Our ref: DOC21/59870-16  
Your ref: SSD-10418

Tegan Cole  
Senior Environmental Assessment Officer  
Department of Planning, Industry and Environment  
Email: [Tegan.cole@planning.nsw.gov.au](mailto:Tegan.cole@planning.nsw.gov.au)

**Advice on Environmental Impact Statement – State Significant Development – Mount Pleasant Continued Operations, Muswellbrook LGA (SSD 10418)**

Figure 13: Aboriginal Cultural Heritage Sites

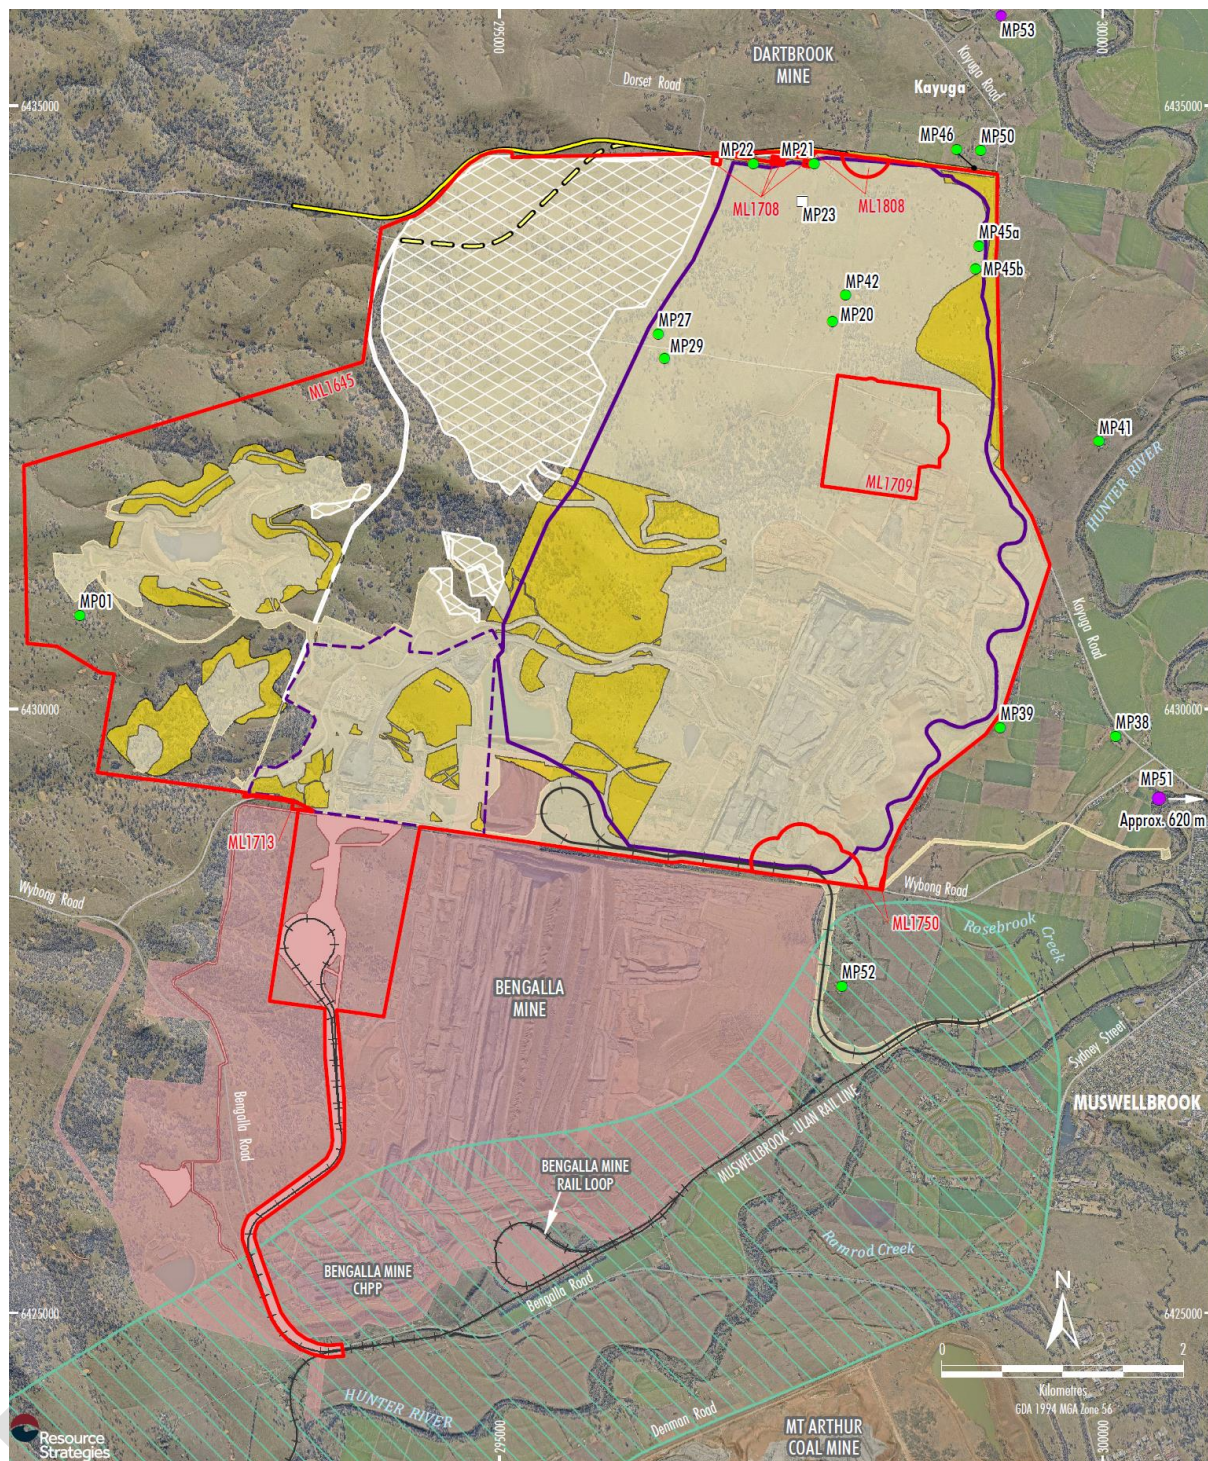
1. Where potential impact areas have not been subject to systematic heritage survey, this should be completed as part of the current ACHAR to inform the impact assessment for the project. The following areas have not been subject to systematic survey and Heritage NSW recommends this be completed so that impacts to Aboriginal cultural heritage in these areas are understood and evaluated within the ACHAR:

- a. Small portions of the additional primary impact areas of SSD Zones B3 and B4, including the alternative alignment of the Northern Link Road that may be adopted, and the remaining 13.8 hectares of zone B3 and B4 that were unable to be surveyed due to property access restrictions.

- b. Potential surface impact areas associated with works subject to future detailed design within SSD Zone C.
2. Where the significance of identified sites has been assessed as 'uncertain' and there is a recommendation to conduct further investigation via archaeological test excavations (such as for the ten sites located in SSD Zone A2R-C), Heritage NSW recommends this test excavation should be undertaken as part of the ACHAR, rather than be deferred to post-approval. This position is consistent with advice provided by the Biodiversity and Conservation Division in their recommended project SEARs (8 January 2020), which identified that test excavation may be required as part of the ACHAR.

3. Reassessment of 'possible scarred trees' should be undertaken as part of the current ACHAR to inform the EIS for the project. Specifically, the scarred trees in Zone A1 and SSD Zone C should be evaluated to determine the origins of the scars and assess the significance of these sites. These results should be included within the ACHAR to ensure the significance and potential impacts to these sites is evaluated.

4. A significance assessment should be undertaken for all recorded sites that are currently listed as being of 'uncertain' significance and which will be impacted by the project (this includes those sites in SSD Zones B2, B4 and C which remain *in situ* and are subject to potential additional impacts, but which have not had their significance assessed). The significance assessment should be undertaken in consultation with Registered Aboriginal Parties (RAPs) and presented in the ACHAR.
